Recommendation Report for Planning Permission for Works or Extension to a Dwelling

REF NO: BR/158/19/PL

LOCATION: Flat 1
4 Nelson Road
Bognor Regis
PO21 2RY

PROPOSAL: Proposed front extension

Proposed Ground Floor Plan

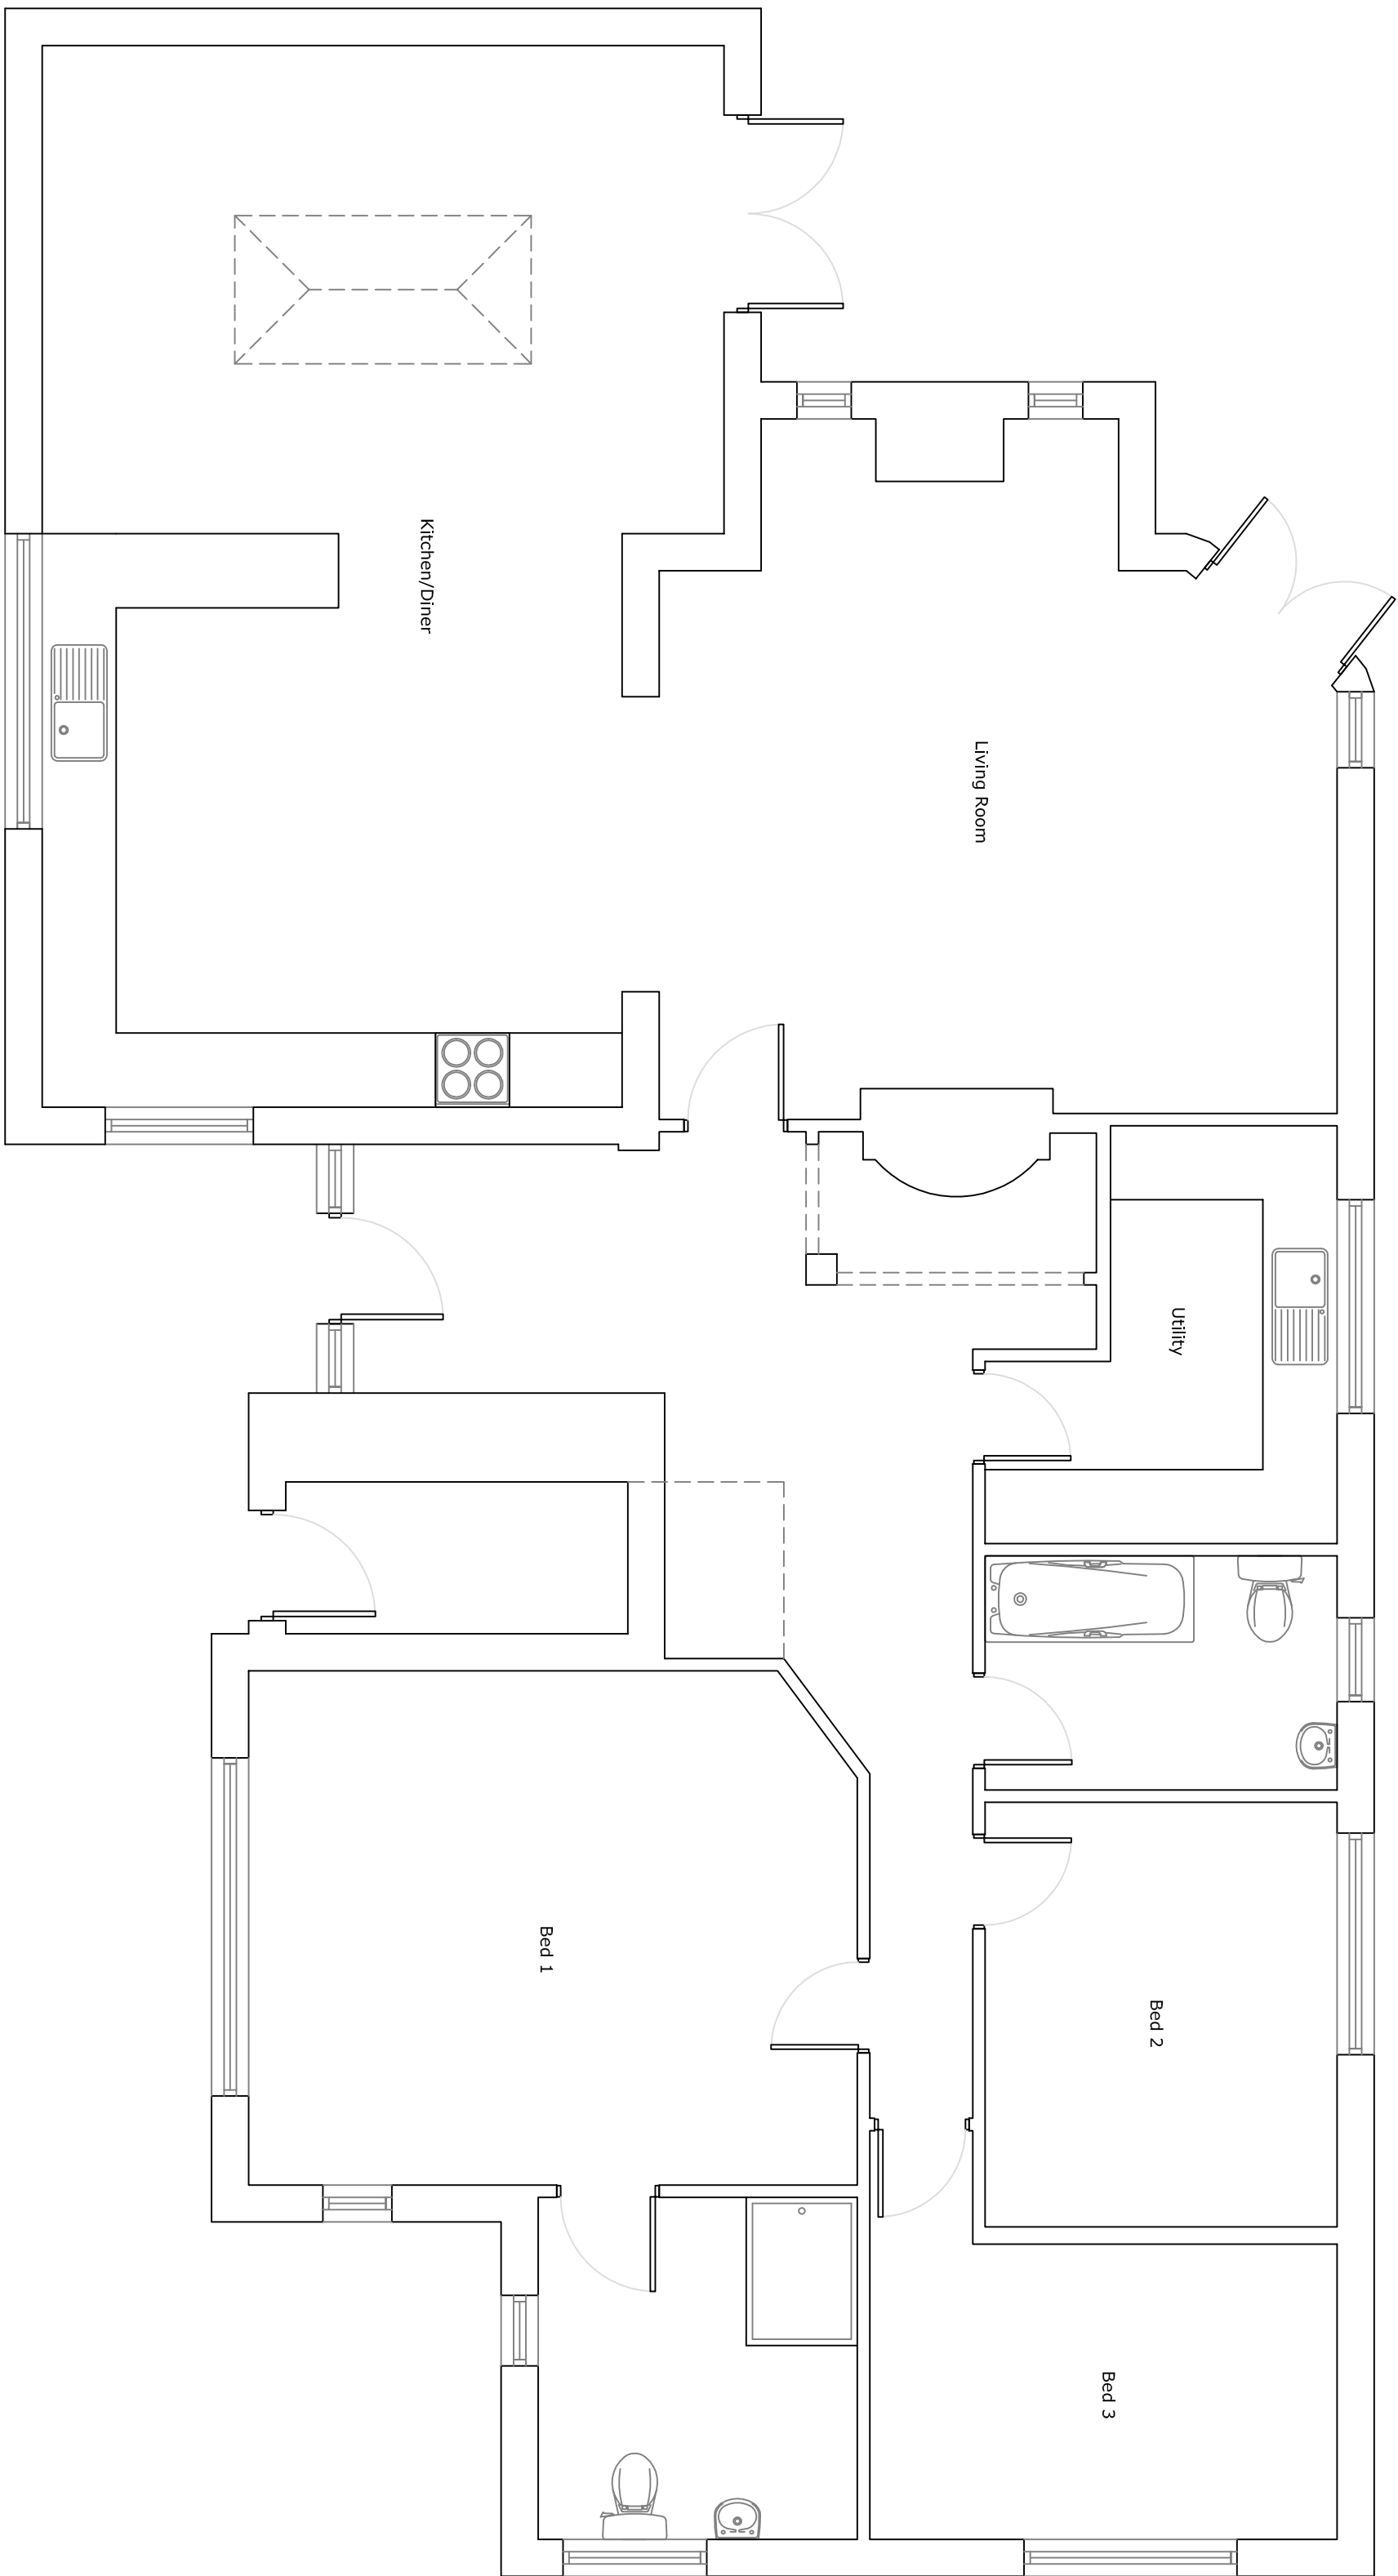
The extension will be situated to the western side of the property and will have a width of 9.2m and a depth of around 6.1m. This retains around 0.5m to the boundary to the west and 6.85m to the rear. The extension will have maximum height of 3.7m.

There is a door to the neighbouring property (4a) facing the host dwelling however there is an existing garage positioned to the western boundary which is to be removed. Whilst the extension is taller than the structure currently in place, it is not considered to give rise to overbearing or overshadowing impacts additional to that which is already achieved with 2.3m from the boundary to the side elevation of No.4a.
